The Planning Inspectorate
National Infrastructure Planning
Temple Quay House
2 The Square
Bristol
BS1 6PN

PINS Reference: EN020022

Date: 13 February 2020

**RELEVANT REPRESENTATION BY PORTSMOUTH WATER LTD ON THE APPLICATION FOR DEVELOPMENT
CONSENT ORDER FOR THE AQUIND INTERCONNECTOR BY AQUIND LIMITED**

Plate 2 – Karst Features (Karst features shown in pale red circles)

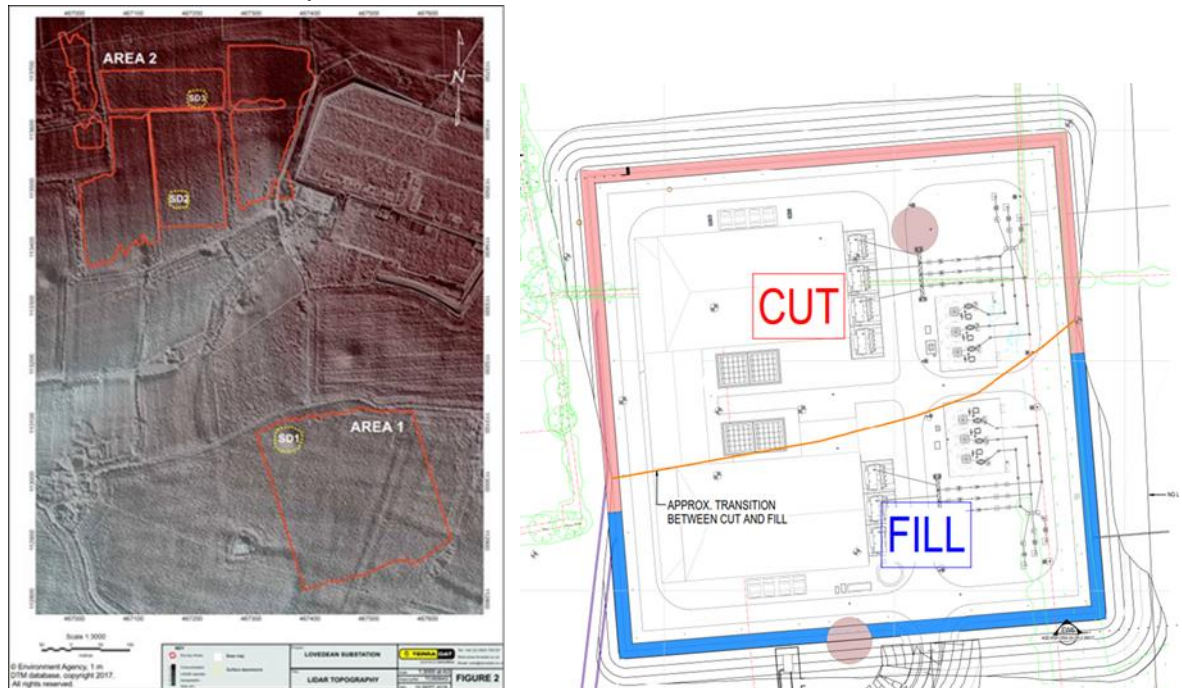
- 5.2. Care must be taken when siting the SUDs features and soakaway crates to ensure solution features are not present or nearby.
